November 20, 2018

SUBJECT: **Request for Modification of Section 404 Individual Permit and Section 401 Water Quality Certification** for the proposed Winston-Salem Northern Beltway Eastern Section from US 158 to I-40 Bus/US 421, Forsyth County, Division 9. WBS Element No. 34839.1.2, TIP Project No. U-2579B.

**Reference:** Section 404 Individual Permit – Action ID No. SAW-2008-03183, issued June 17, 2014 and modification issued July 2, 2014.  
Section 401 Water Quality Certification – NCDWR Project No. 2014090 issued April 11, 2014 and modification issued July 28, 2014.

PERMIT DRAWING MODIFICATION FOR SITE 23 AND 28

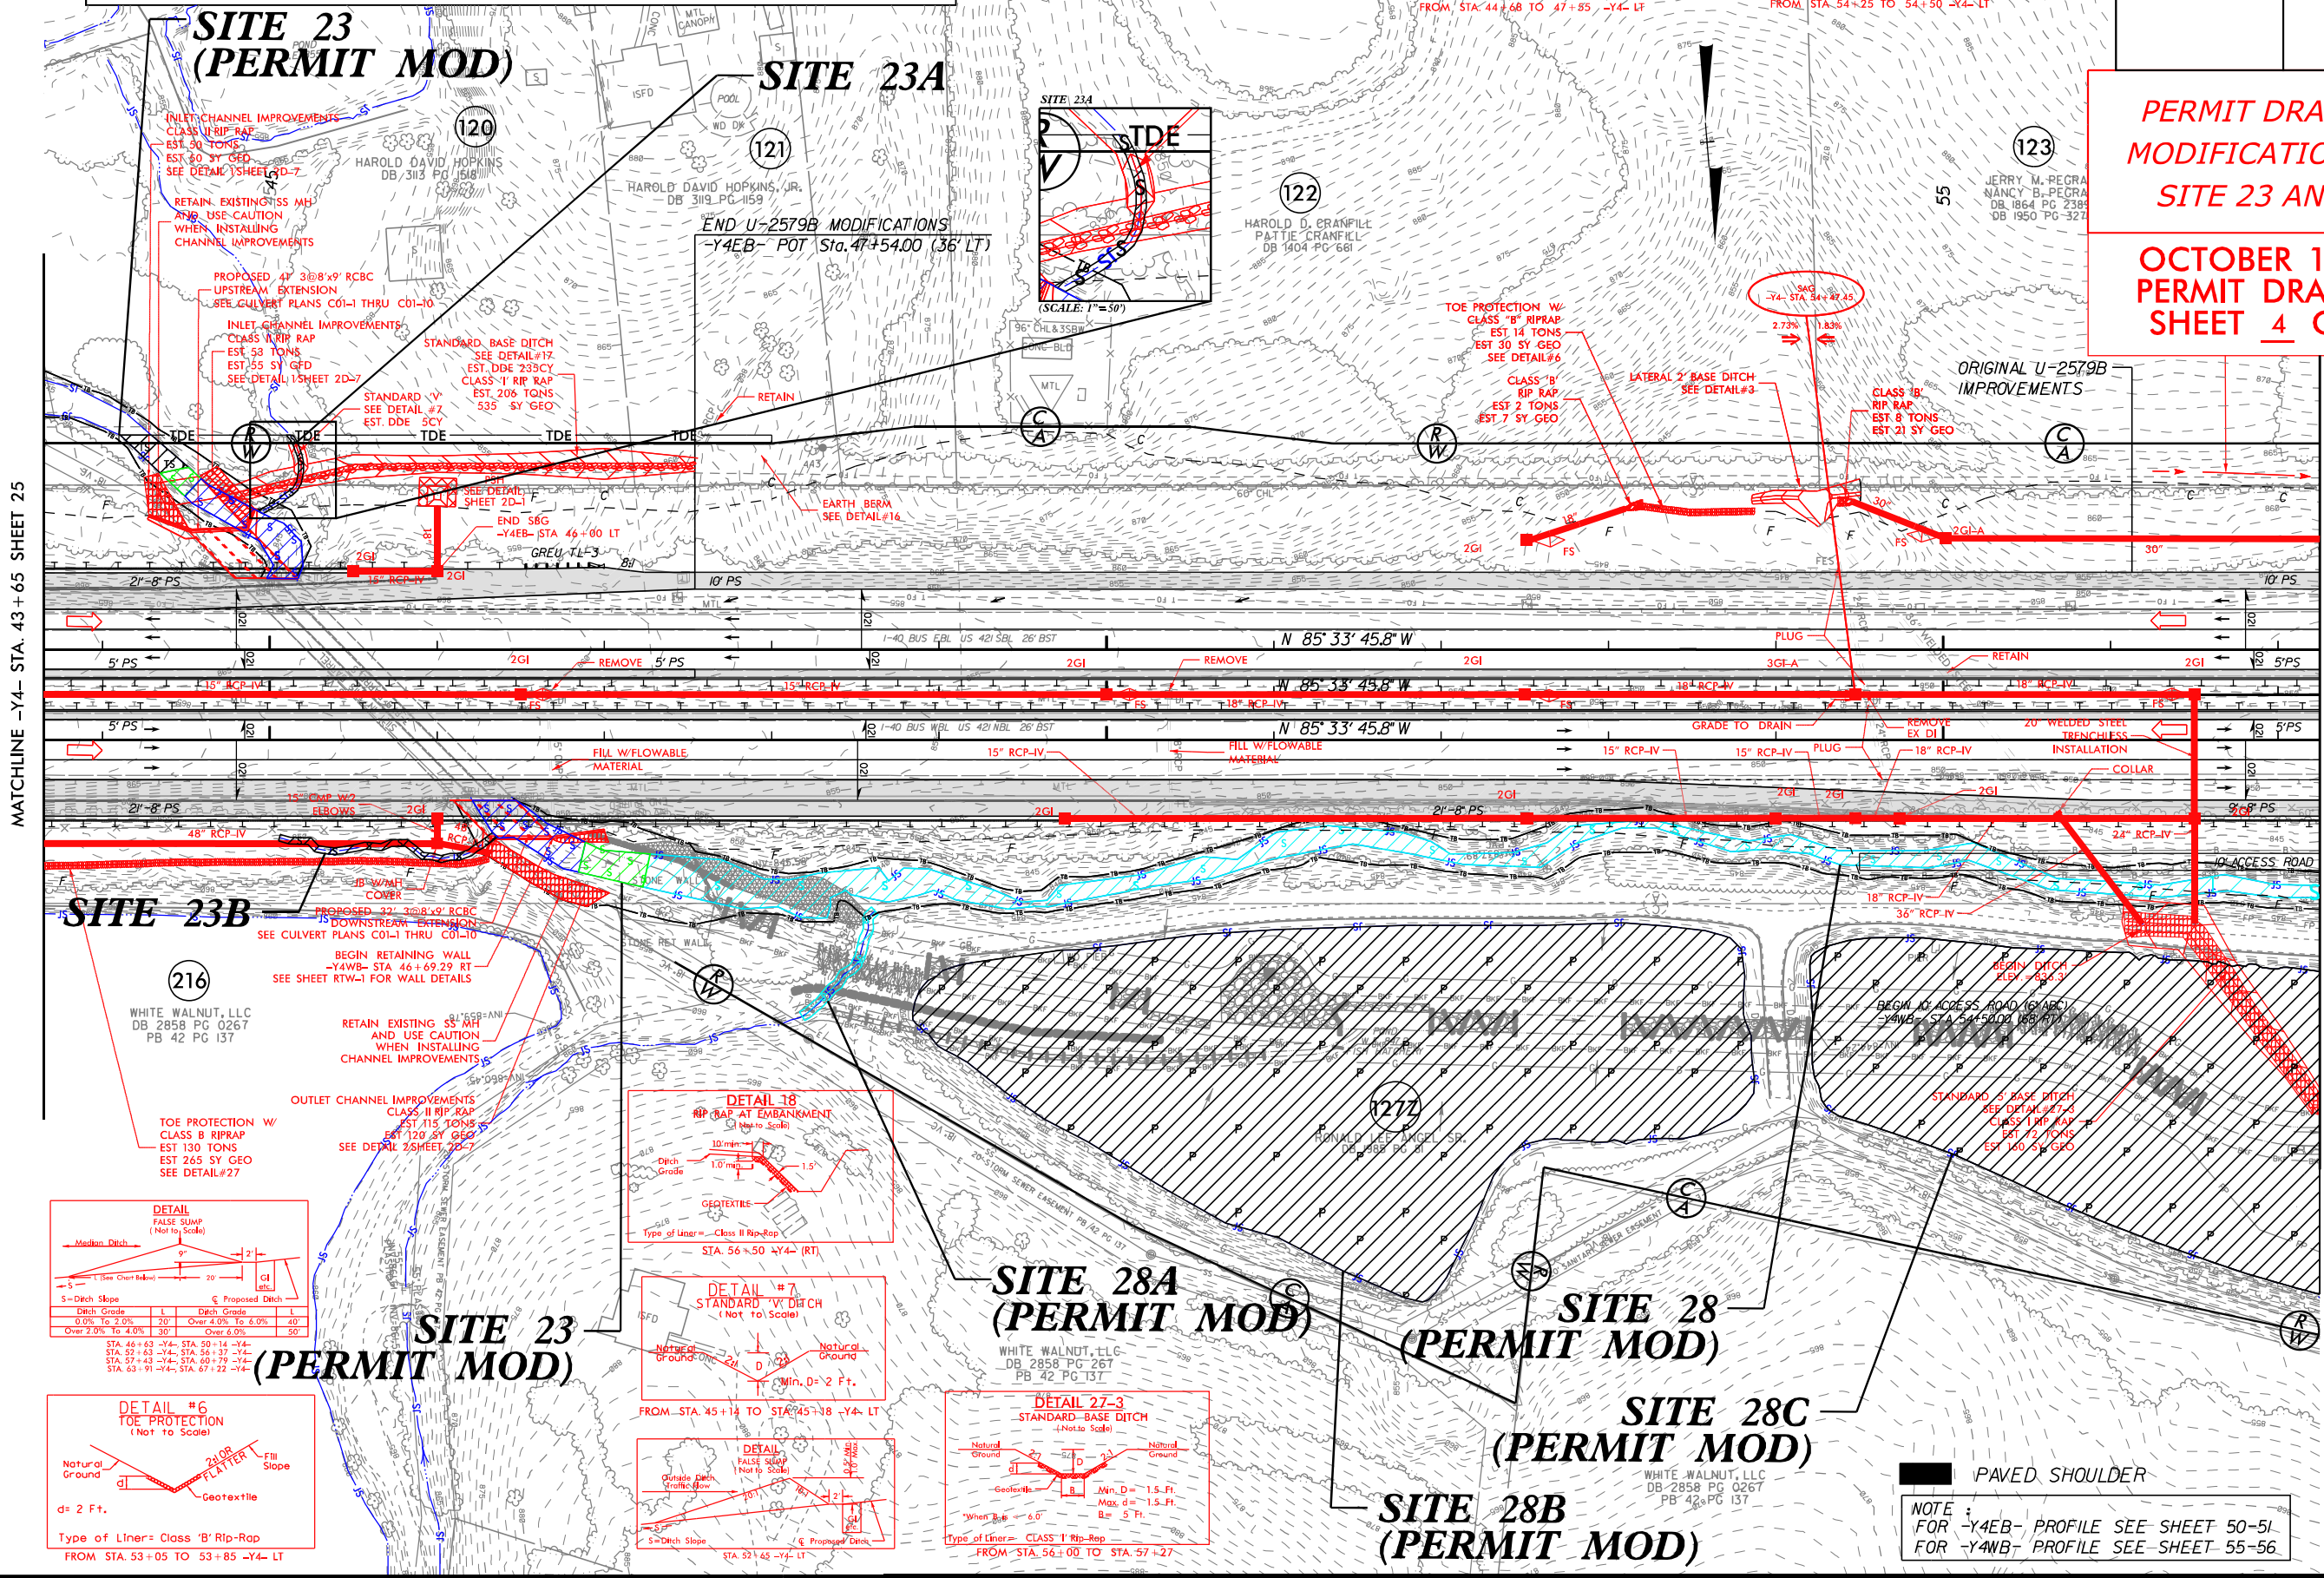
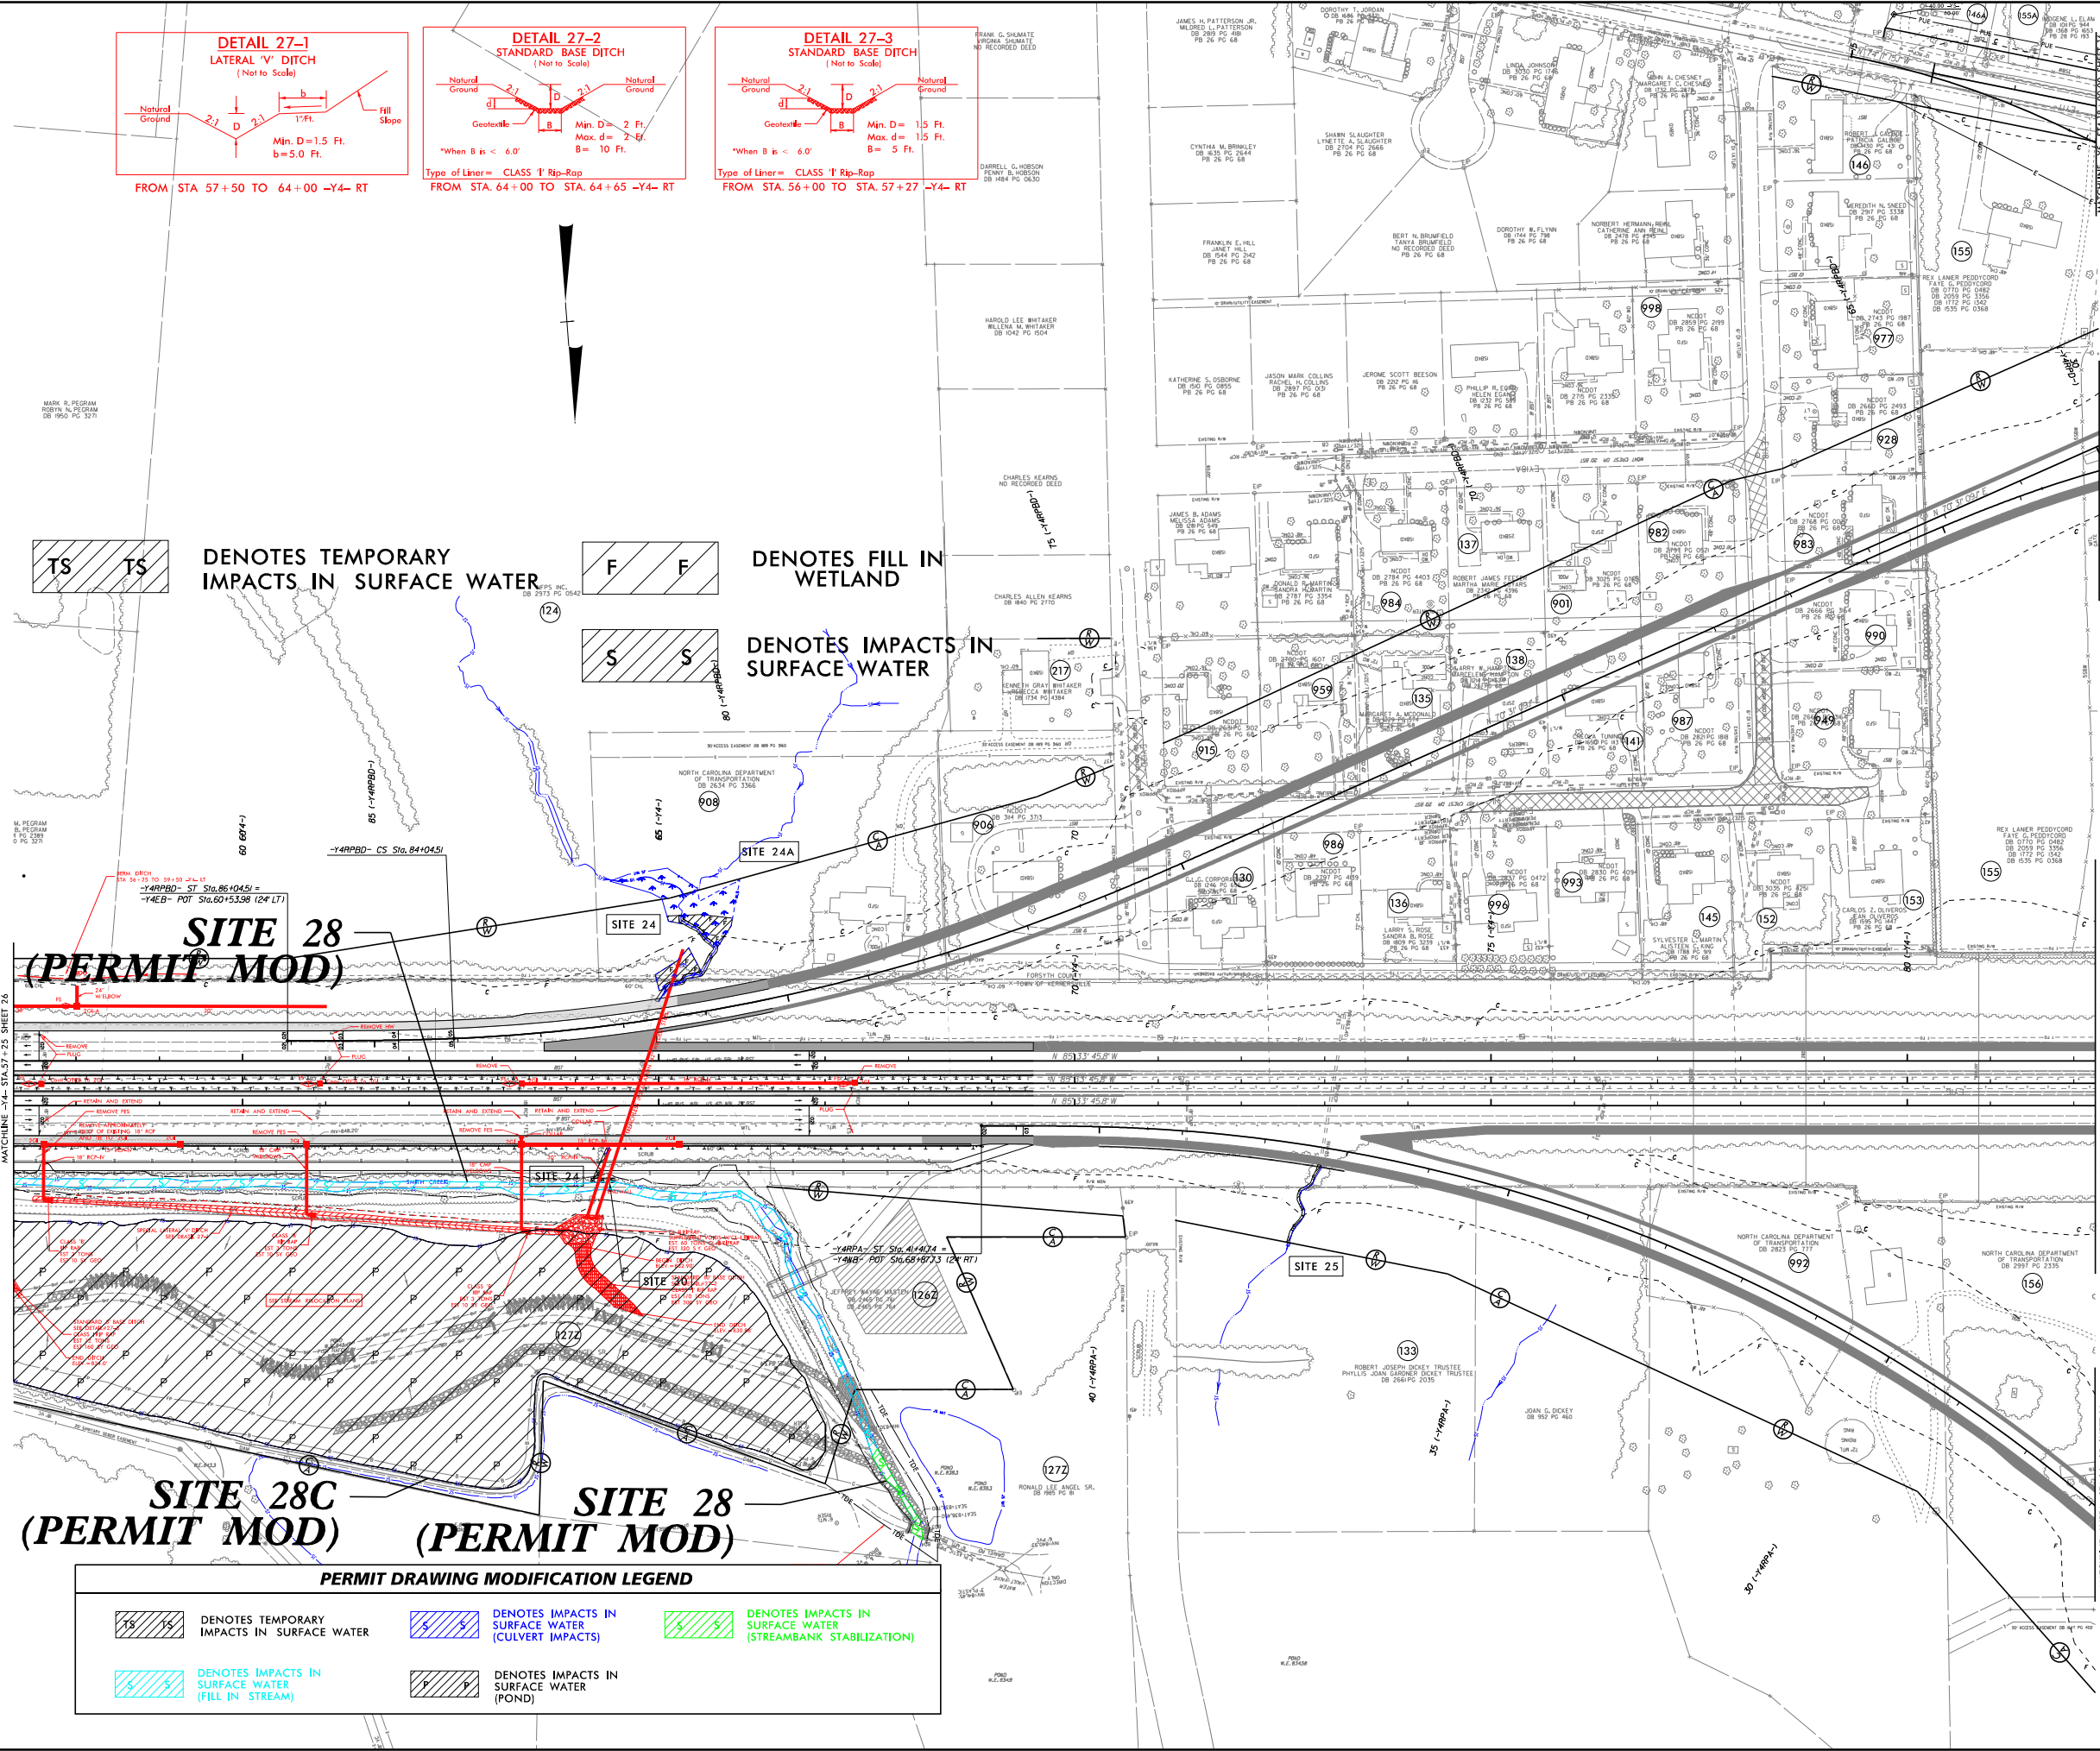
At permit site 28, the low flow barrel will not be buried 1' below the stream bed. The bed of Smith Creek has a predominately bedrock bottom making culver burial infeasible. There will be a spill over channel constructed on top of the exposed portion of the culvert, and it will be lined with Armorflex in the event of overtopping. The outlet of the low flow barrel will have a rip rap pad of Class II to prevent scour in the event of overflow. The 2 high flow barrels will have 1' concrete sills at the inlet and outlet. Floodplain benches will be constructed with Class II rip rap at the inlet and outlet. The high flow barrels will be backfilled with native material and/or Class I rip rap.
